Outline application with some matters reserved for demolition of existing detached dwelling & erection of 2 no. 5 bed dwellings, double garage & alterations to existing access

69 Coastal Road Kingston

Thank you for your internet representation made on 5th January 2012 which has been recorded as **an objection** with the comments as follows:

PROJECT			Proposed development at 'Simcar' Coastal Road, East Preston
SUBJECT			Plot 1 -Indicative Plans and Elevation
SCALE	DATE	DRAWING No	
1: 100	Nov 2011	11 / 46 / 02	
DRAWN	CHECKED

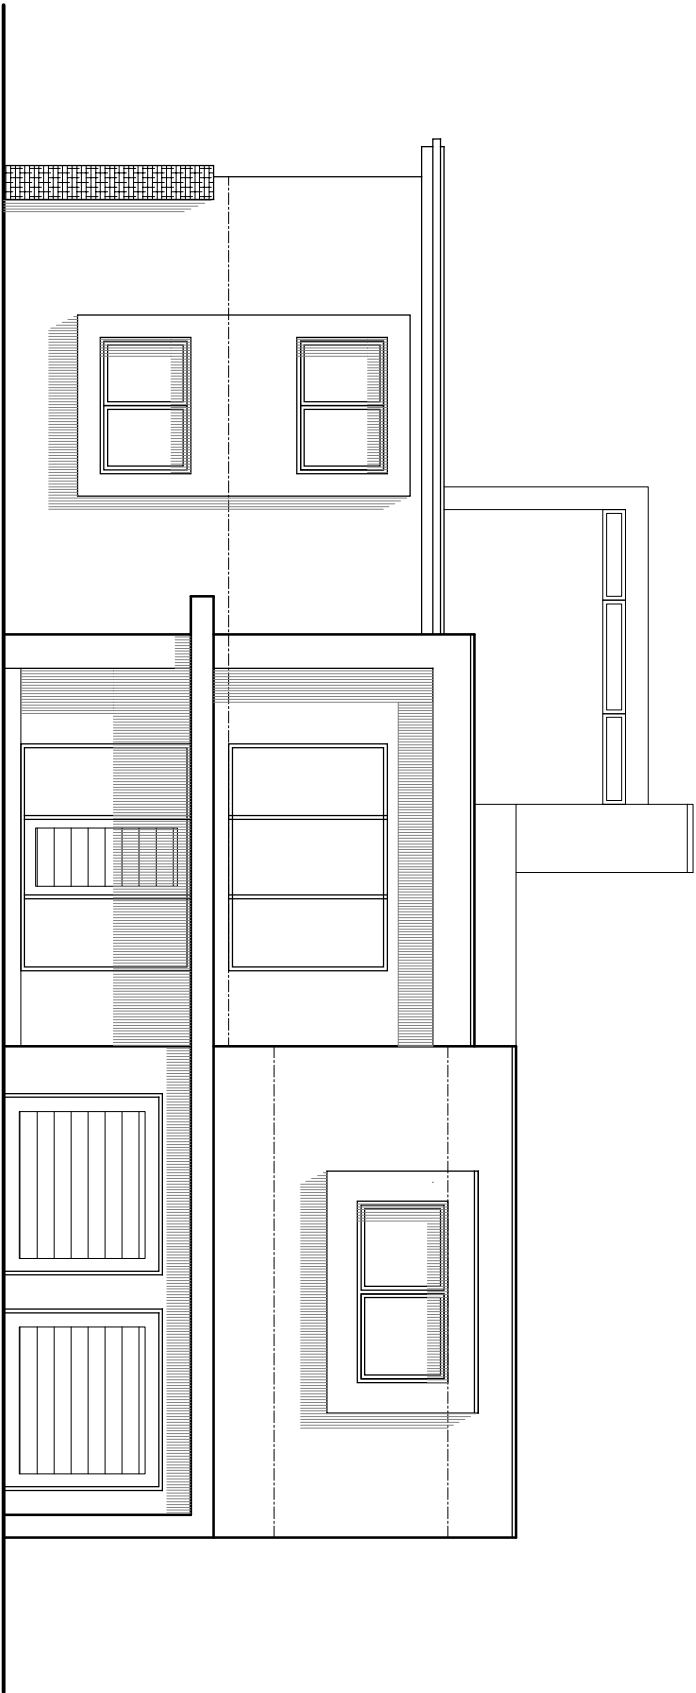
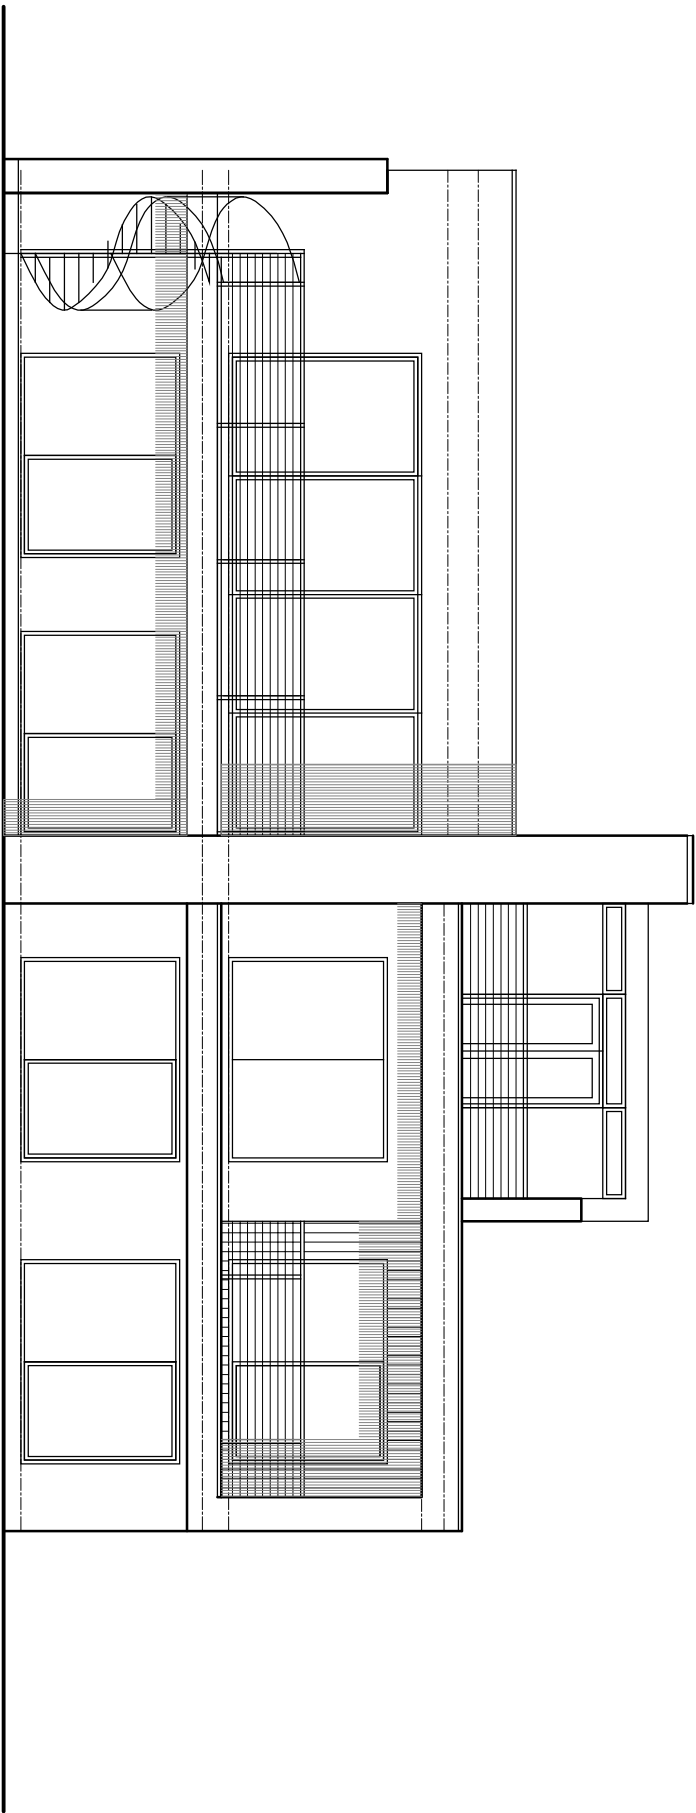
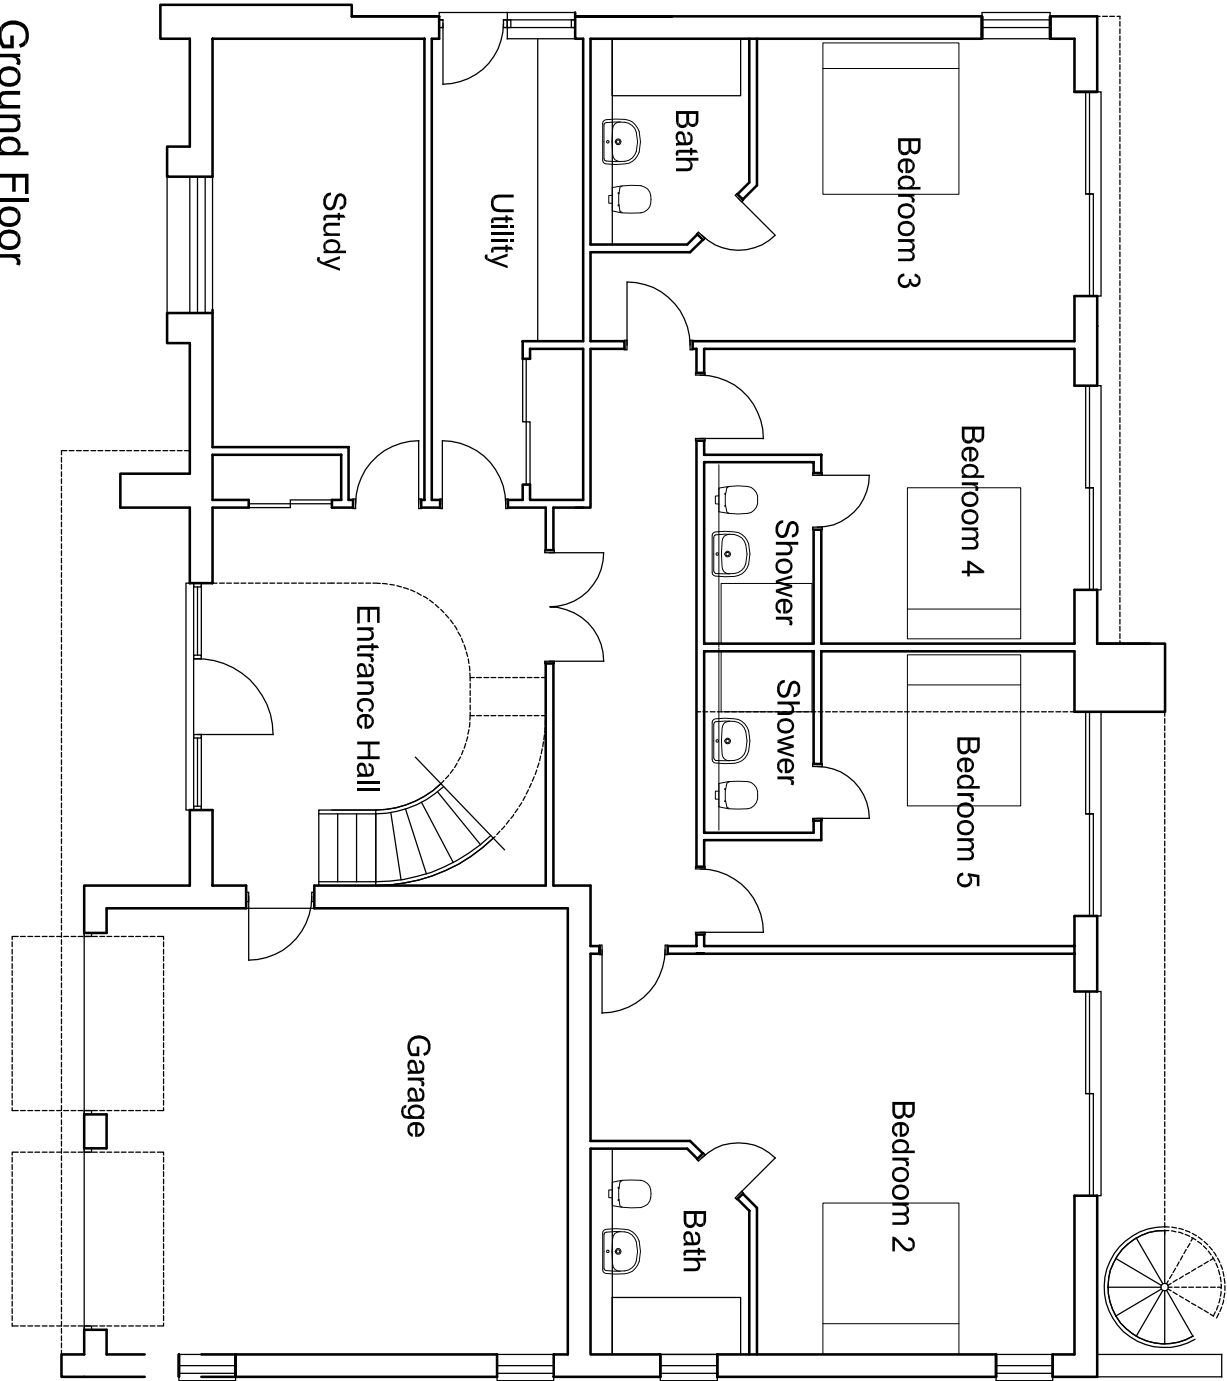
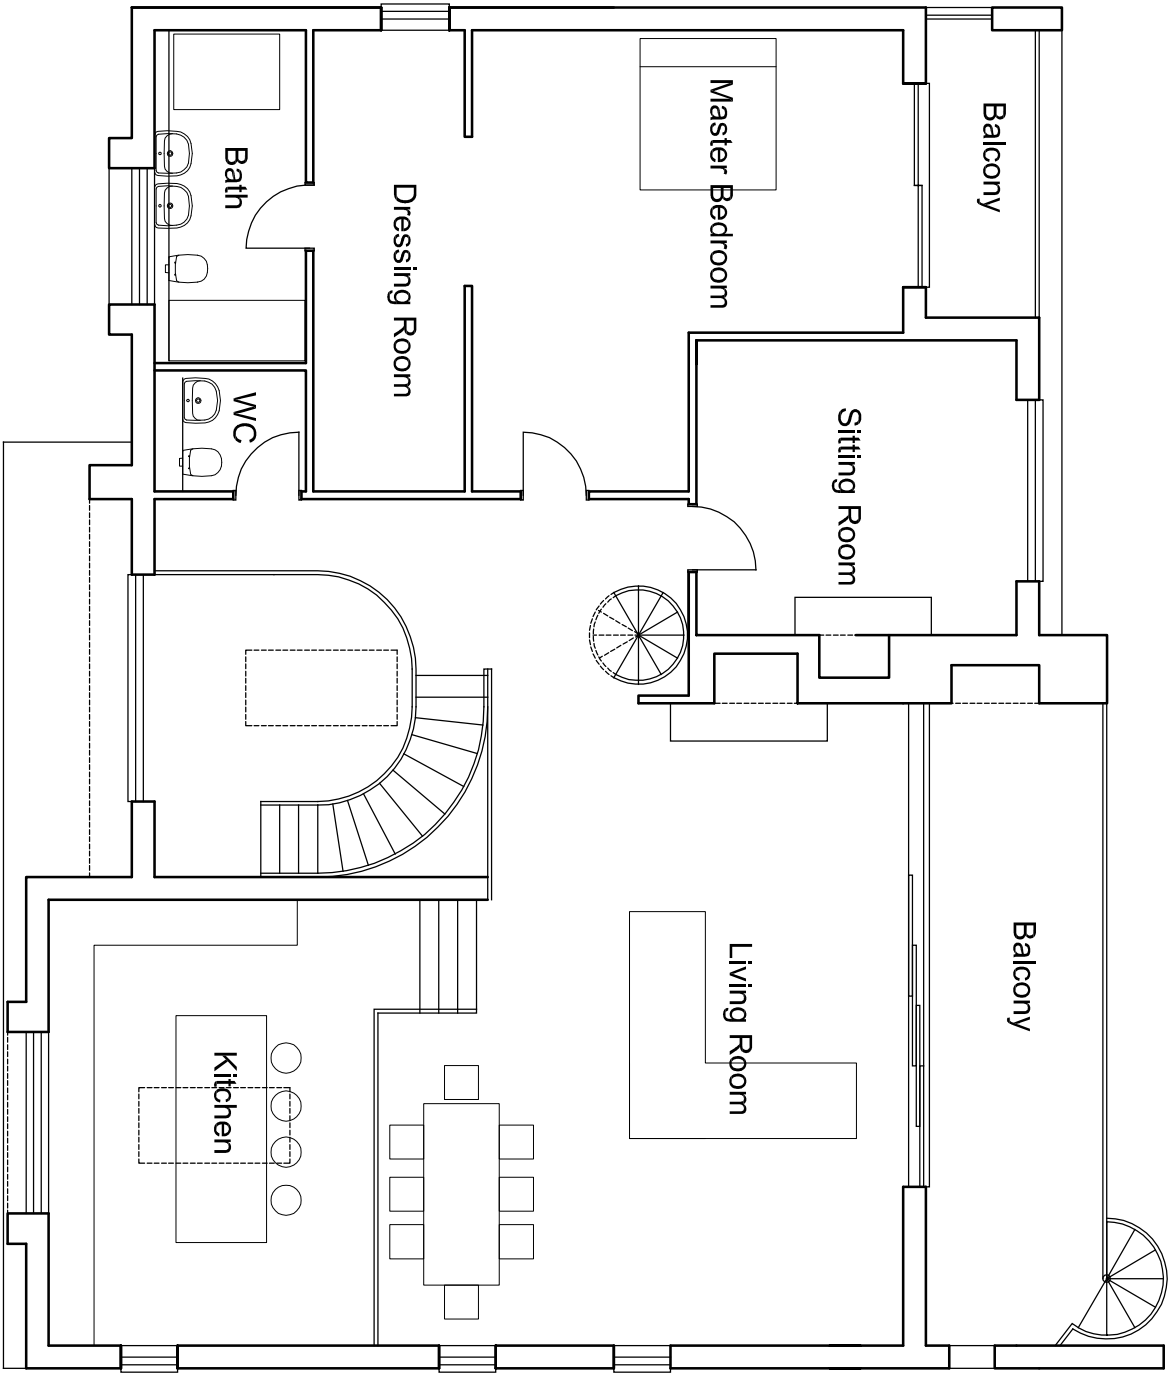
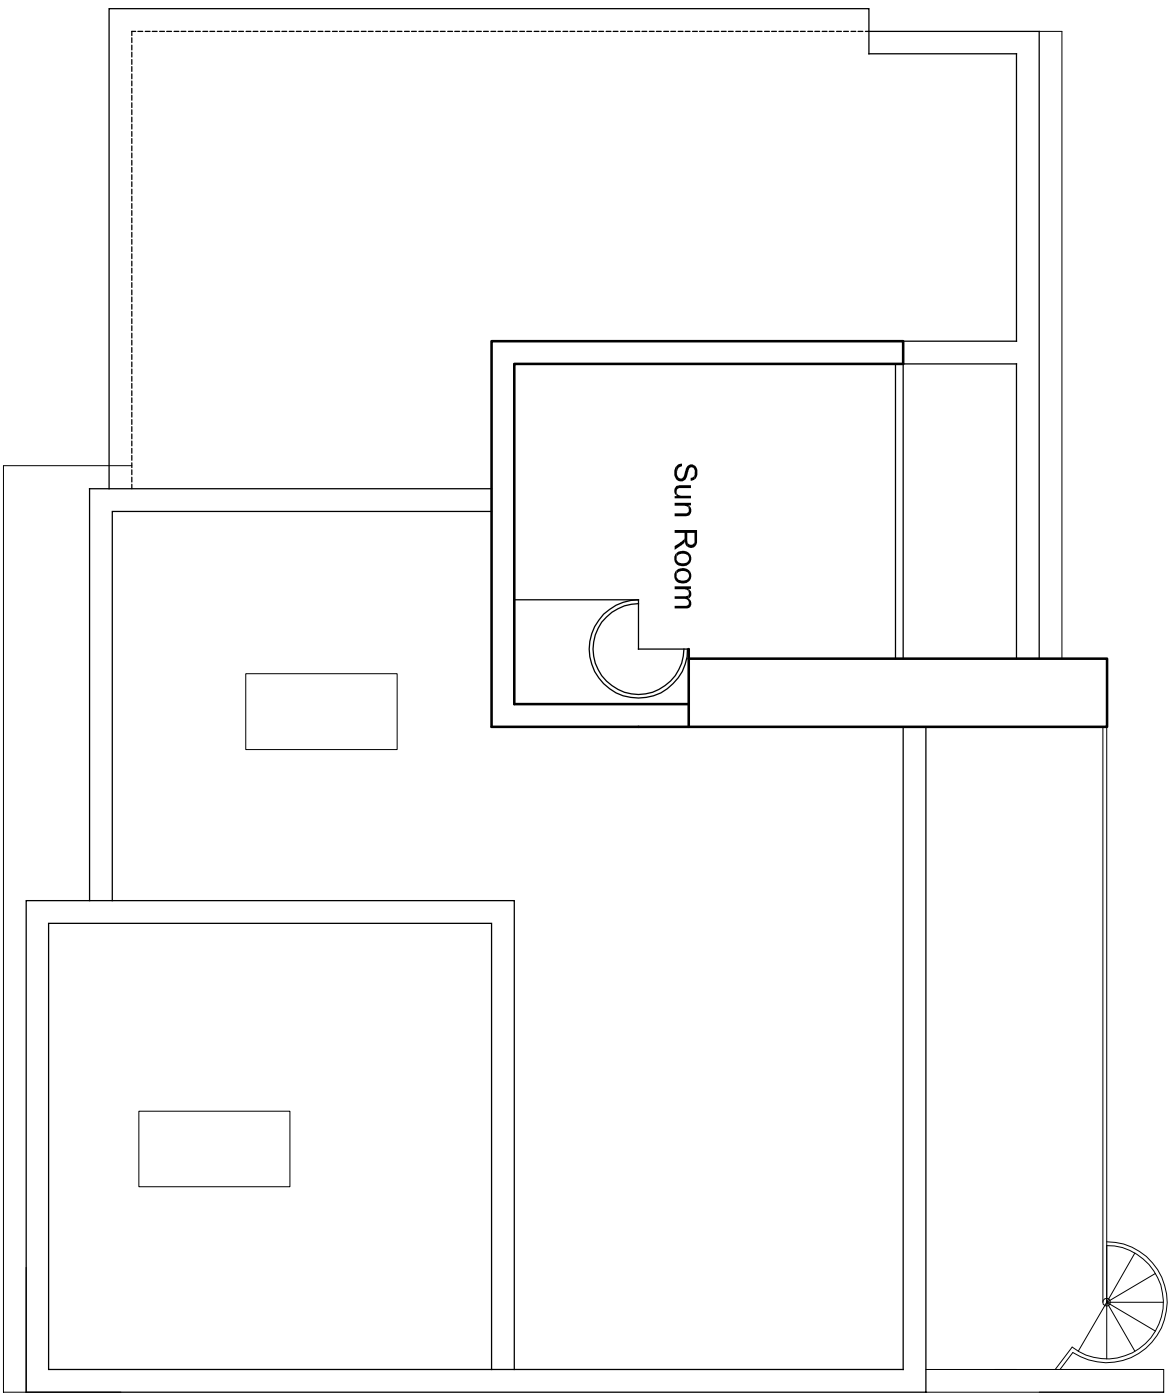
1. The proposed houses are to be built further south than the existing which will spoil the line as you look along the West Kingston greensward. This repositioning will also afford the new house direct views of our garden and into the back of our house which the current house does not have.

2. The proposed west house is to be built nearer our own plot than the existing and as

such will be intrusive, and inhibit our light.

4. The flat roof on second floor level will directly overlook both our garden and into the back of our house. If you were to allow this to be allowed as terrace

we ask that they be screened so as only to afford a view forward to the sea. At any rate, even as a flat roof, we would ask it to be screened on the side of our garden

5. The terraces on the first floor will directly overlook both our garden and into the back of our house. We would ask that if you do allow this, they be screened so as to only afford a view south towards the sea.

6. As the plans are outline, it is not clear whether there are any windows on the west side overlooking our garden. We would take objection to any windows on the side of our house. I believe currently there are none, and at any rate, the site of the existing house does not overlook us, whereas the intended houses, being further forward will directly overlook us.
